SICEEP, SSDA4 – Response to Department of Planning and Infrastructure Submission

Topic	Response
SICEEP, The Haymarket Precinct - (Western, North West and South West Plots - SSDA 3, 4 &5)	
Built Form	
<p>1. The Department notes that the only architectural drawings provided are 'illustrative'. The Department requires finalised drawings of the proposed drawings for the proposal.</p>	<p>Noted. A final set of development application drawings incorporating all amendments proposed under this response to submissions is provided for approval by the Department of Planning and Infrastructure.</p>
Traffic and Transportation	
<p>2. Having regard to traffic safety, further details of the proposed billboard are required including:</p> <ol style="list-style-type: none"> photomontage from a driver's perspective; further justification for a changeable as opposed to static message billboard consideration of impact/conflicts with existing RMS variable signage 	<p>Noted. As set out in the Response to Submissions two additional photomontages have been provided in order to illustrate the driver's perspective of the proposed billboard:</p> <ul style="list-style-type: none"> NWP Billboard View A – View lo

Figure 3.2.1 Excerpt from 'Cycle Strategy and Action Plan. 2007 - 2017' - Proposed regional network.

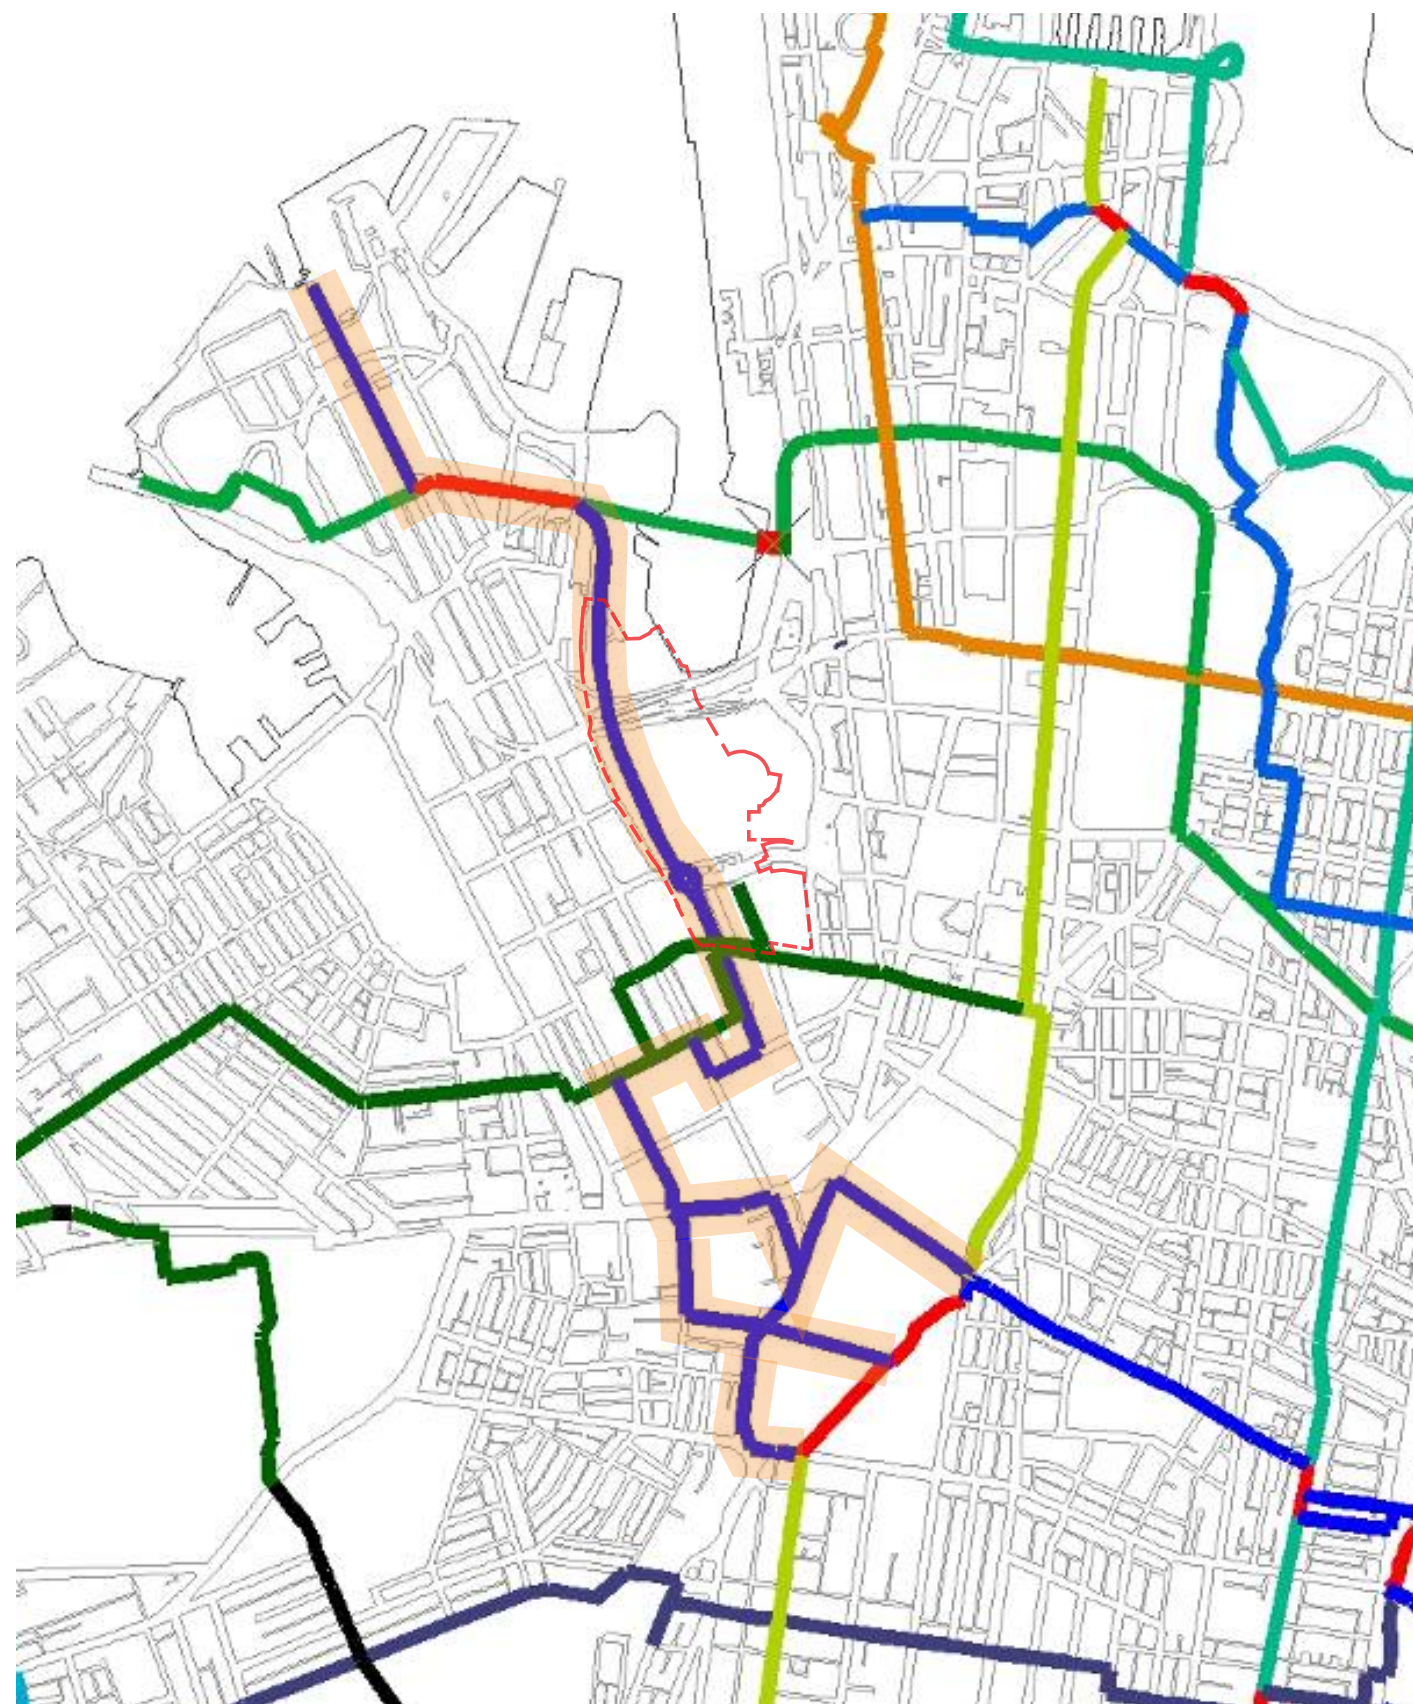
<p>3. The proposed cycle routes should be reviewed for consistency with the current regional bike route network</p>	<p>The proposed cycle connections have been reviewed and are consistent with the current regional bike route plan and broadly align with the City Centre Access Strategy of Dec 2013. The enhanced north south connections along Darling Drive and via a through route along the Boulevard, improves connectivity in the precinct as do the east-west cycle routes aligning with the western regional route via Liverpool Street.</p>
<p>4. Consideration should be given to meeting the City of Sydney's bicycle parking rates (DCP</p>	<p>SSDA4 currently (as exhibited) has allowed for the following regarding bicycle parking to meet an overall Green Star rating for the office component of 5 Stars:</p>

Figure 3.3.1 Section through WSUD area

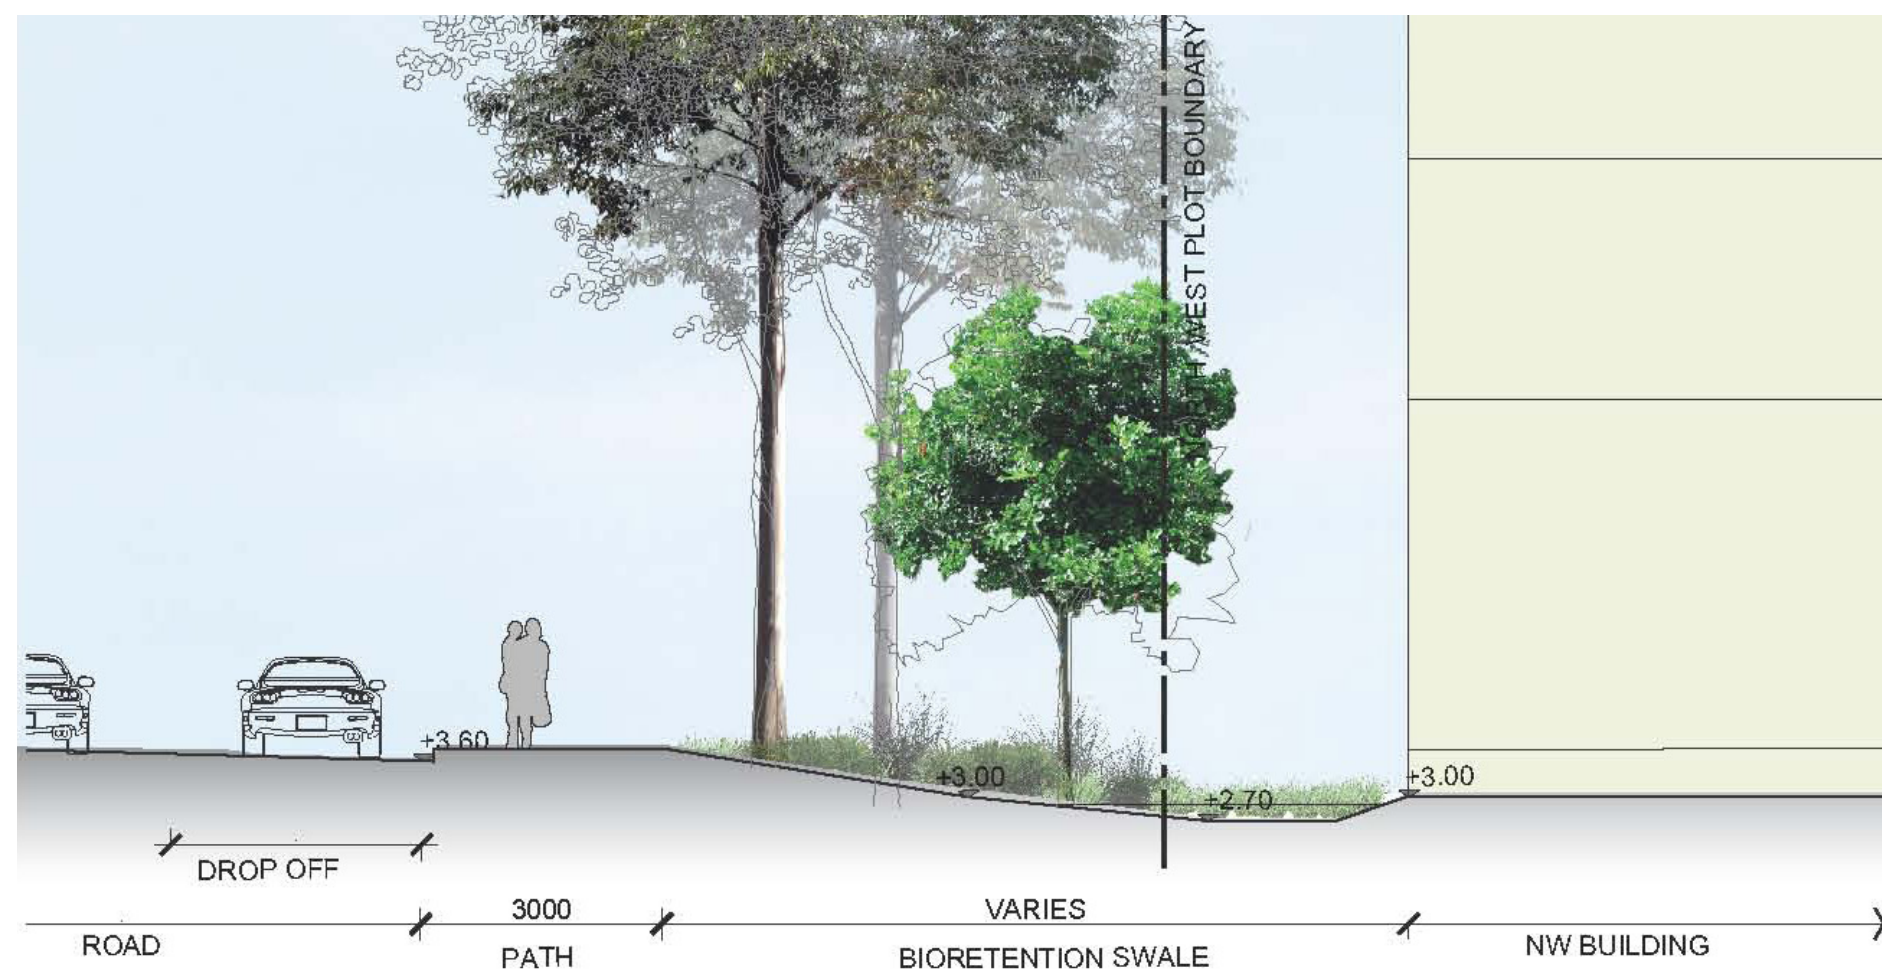
<p>10. The Department notes that Sydney Water has raised concern regarding water, wastewater and stormwater assets. Consideration and response to Sydney Water's comments is required.</p>	<p>The considerations of Sydney Water have been addressed sequentially in the Response to Sydney Water Submission within Appendix A.</p>
<p>Crime Prevention</p>	
<p>11. The Department considers that the security of the western side of the development where it abuts the landscaped area and the bicycle storage area should be improved. The Department notes Council's comments seeking improvements in this regard.</p>	<p>Noted and agreed. No objection is raised with the imposition of appropriate conditions of consent.</p> <p>CCTV monitoring will be undertaken by building management and the buildings security contractor as part of the building management plan.</p> <p>The proposal has been reviewed in response to CPTED concerns along the western side of the development and adjustments have been made to improve sight lines and passive surveillance whilst maintaining the functionality of a WSUD area. The path has been moved away from the building face to improve surveillance and sightlines. As such the WSUD zone has been shifted to the building face and the path moved adjacent to Darling Drive (to be provided as part of SSDA5). This realignment allows for rationalised pedestrian movement, servicing of the dropoff bay and an improvement of safety and sight lines. Surveillance is provided from the student housing and passing traffic. Safety is further ensured through low level planting and adequate lighting provided from Darling Drive street lighting. Appendix D – Supplementary Public Domain Report and Drawings provides the detail in this regard.</p>
